**Consultation Response from Chris Bembridge KC,
Highways Development Management**

**2022/93938 First and Second Floors, Shopping Precinct, New Street and Albion Street,
Huddersfield, HD1 2TR**

**Change of use from A1 (business retail and storage) to C3 (residential) 18 studio flats at first
and second floors and external alterations**

Date Responded: 05/12/23

Proposed Ground Floor Plan

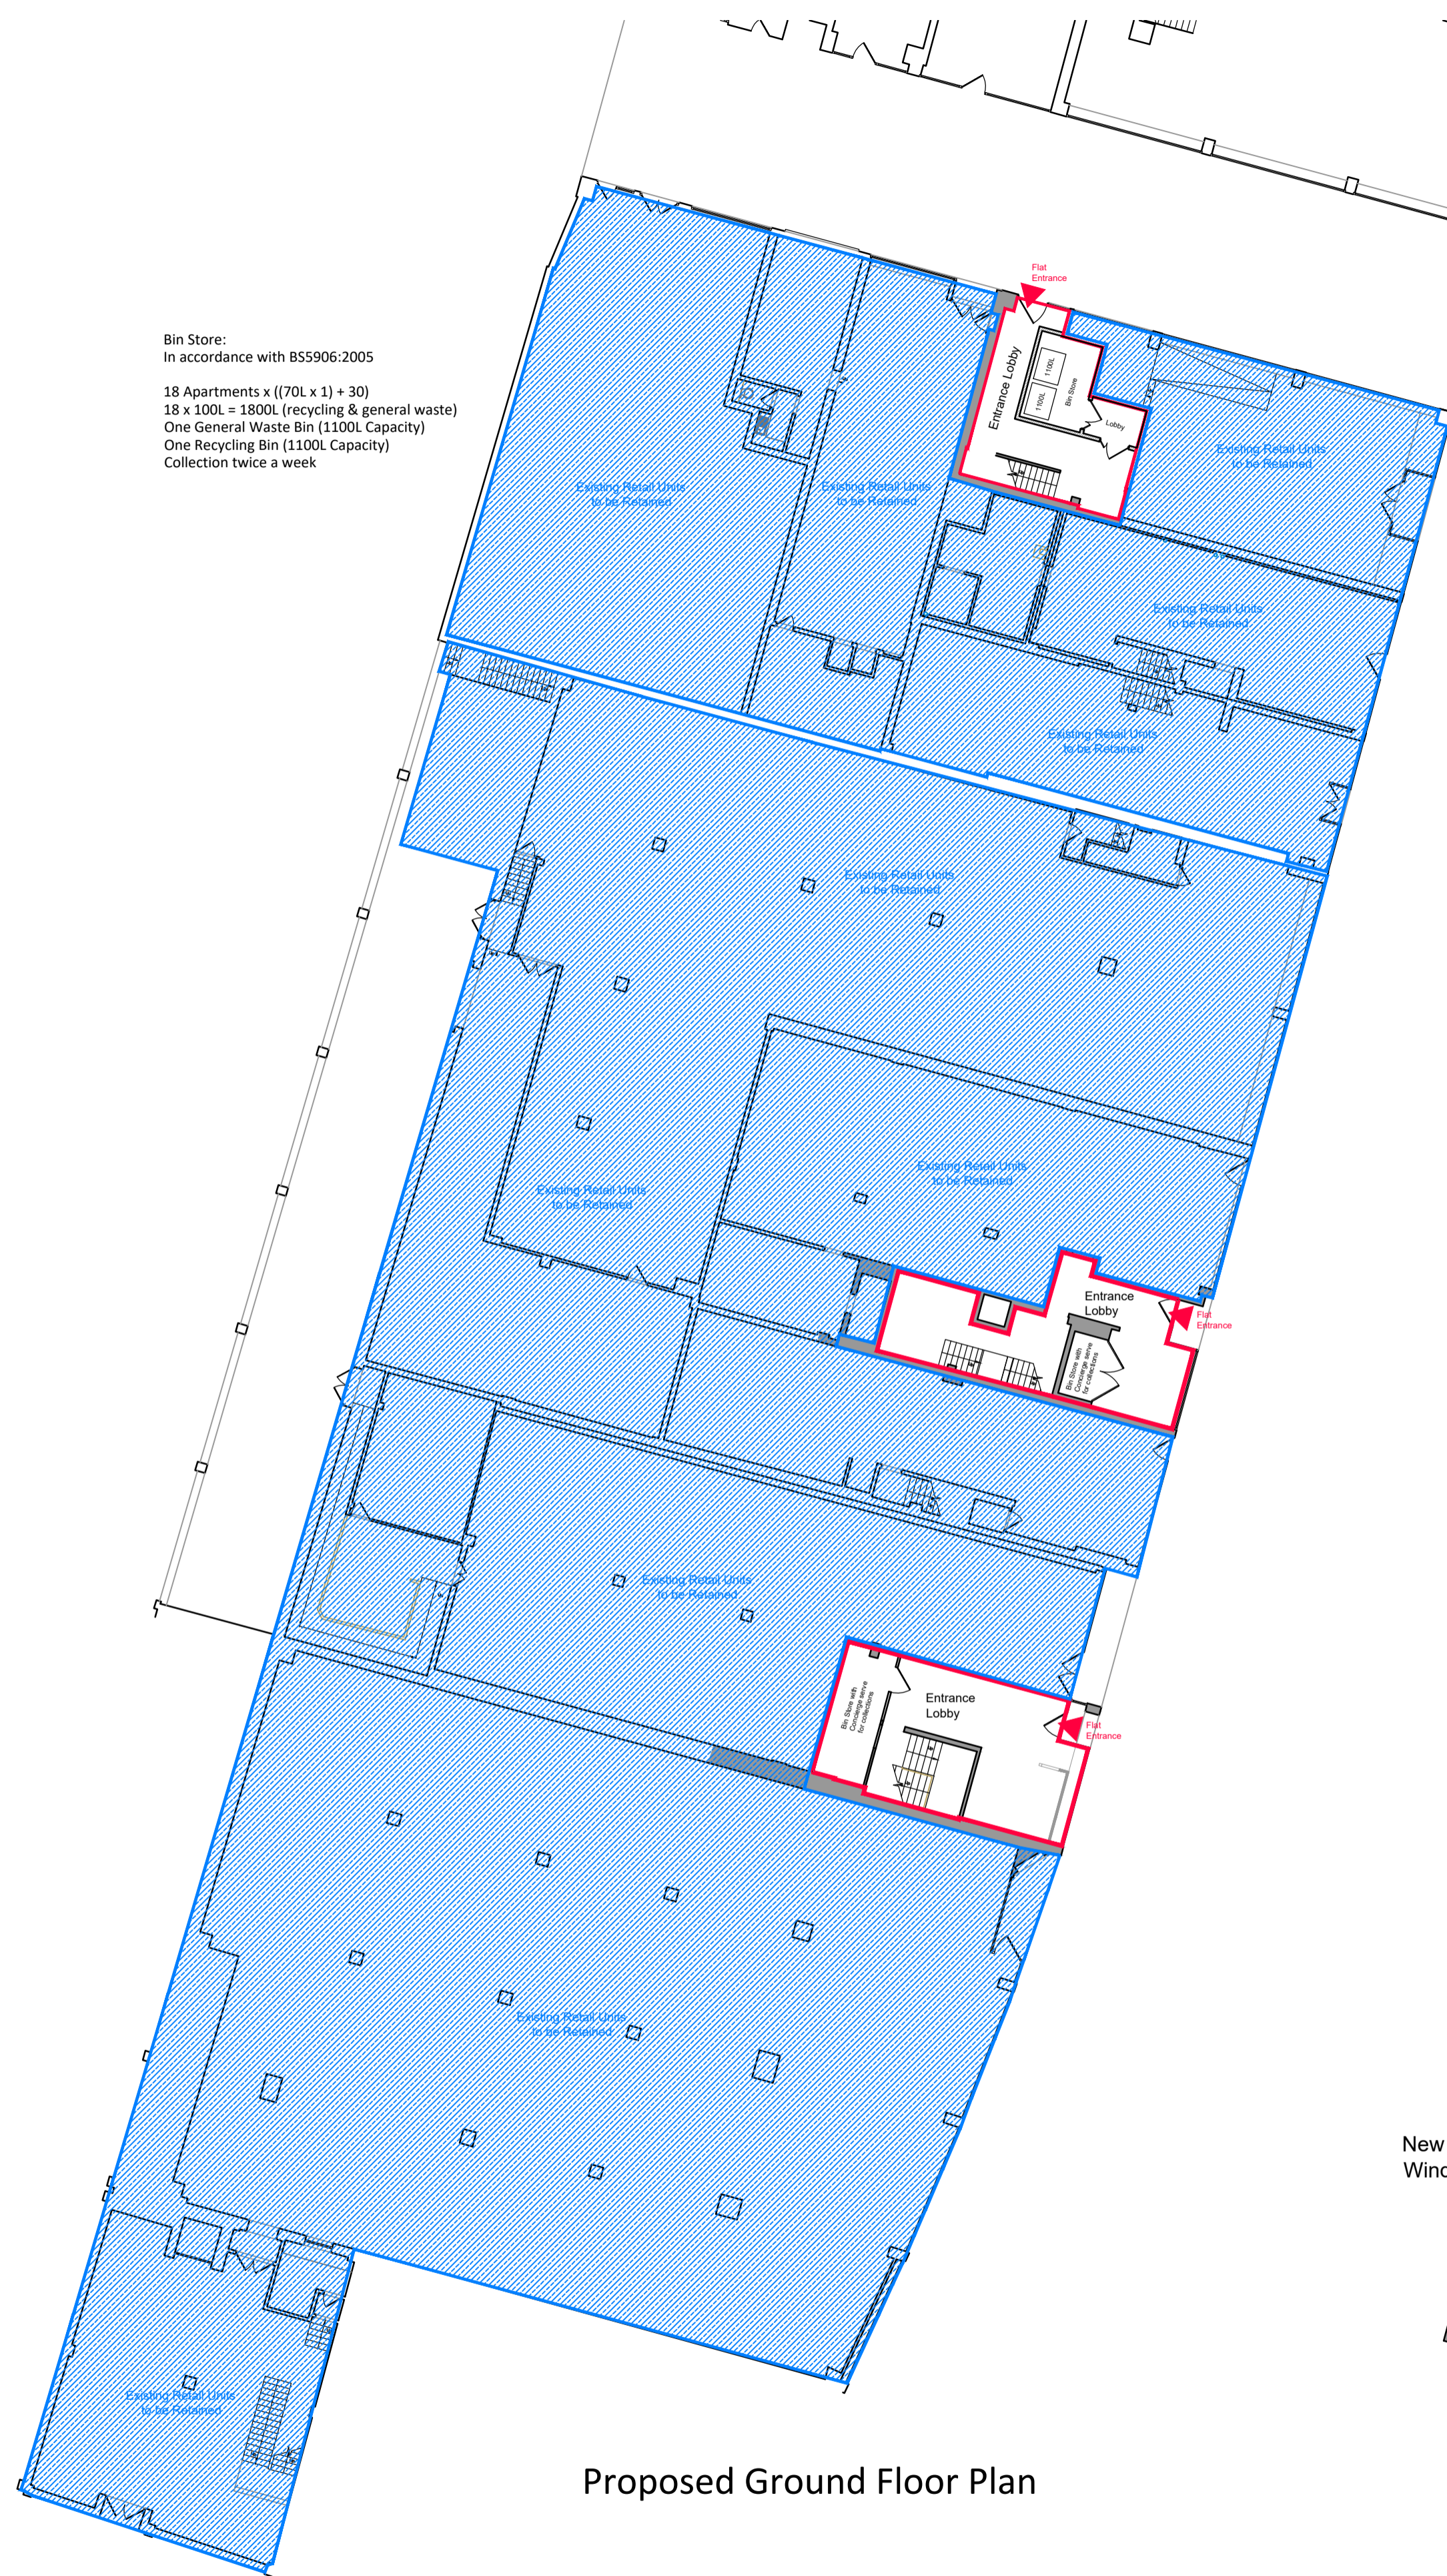
The waste storage area is likewise ill thought out and badly located as again only 11 of the flats would be able to directly access the bin store without needing to take their waste in to the street and carry it around the building and this carry distance would be above the recommended distances provided in building regs and Kirklees waste storage and collection guidance. The Kirklees waste strategy team have provided a consultation response to the proposed waste storage, and we defer to their judgement on this. However, the waste storage location is accessed via a pedestrianised zone that is not a suitable route for a refuse vehicle to get within the recommended bin drag distances. Due to this, the collection would need to be made from either Princess Street (approximately 90m from the bin storage point) or from Albion Street (approximately 105m from the bin storage point). There is insufficient space on New Street to allow a refuse vehicle to turn and we would not wish to see a refuse vehicle having to reverse along a pedestrianised retail area for highway safety reasons. We would like to see a waste management strategy plan that ensures that waste can be collected safely and that there will be no waste left on the adopted highway or within any pedestrianised zones within the town centre. This should be conditioned as pre-commencement.
